Rezoning Transportation Analysis

Petition Number: 2022-190

Date	Description
3-22-23	First Review (IW)
4-20-23	Second Review (IW)

**RZ-1.0**

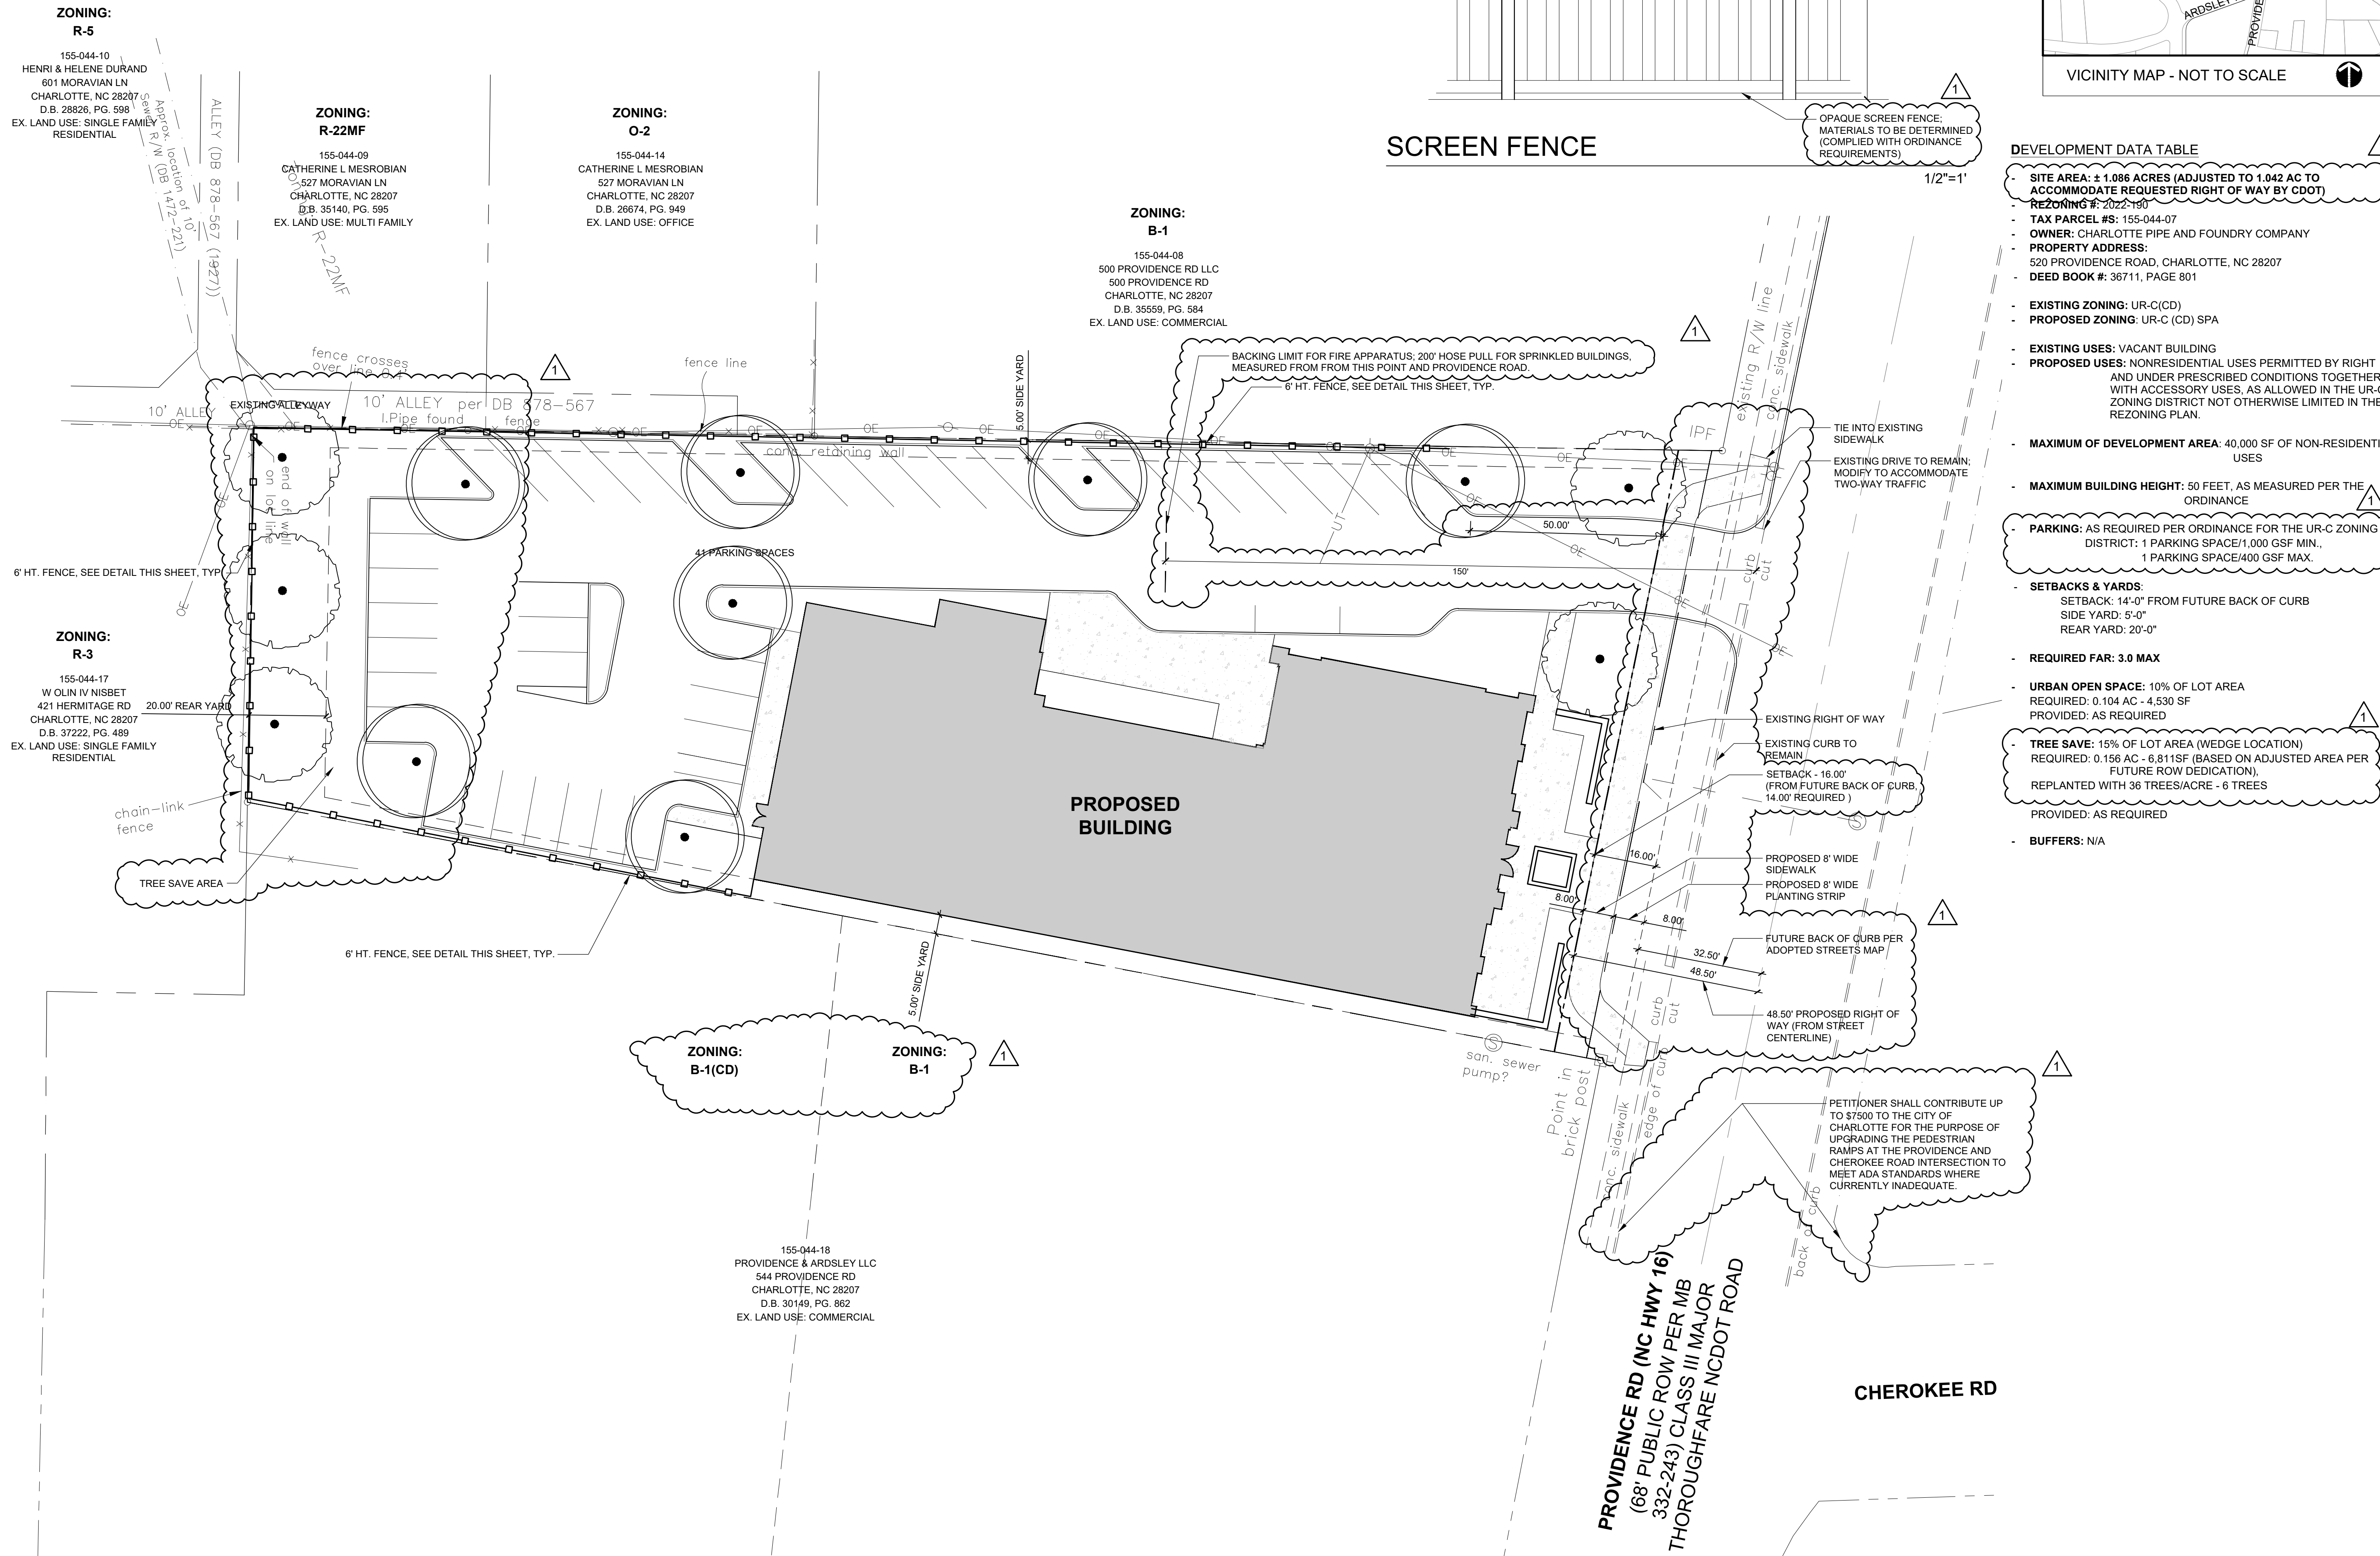
6. CDOT requests site plan and conditional note(s) be revised to commit to upgrading intersection for ramps to meet ADA standards and upgrading pedestrian crossings for APS.

Comment Clarification 4-20-23: CDOT is requesting petitioner construct the ADA ramp(s) rather than a funding contribution. Request to commit to reconstruct ramps or remove site plan note.
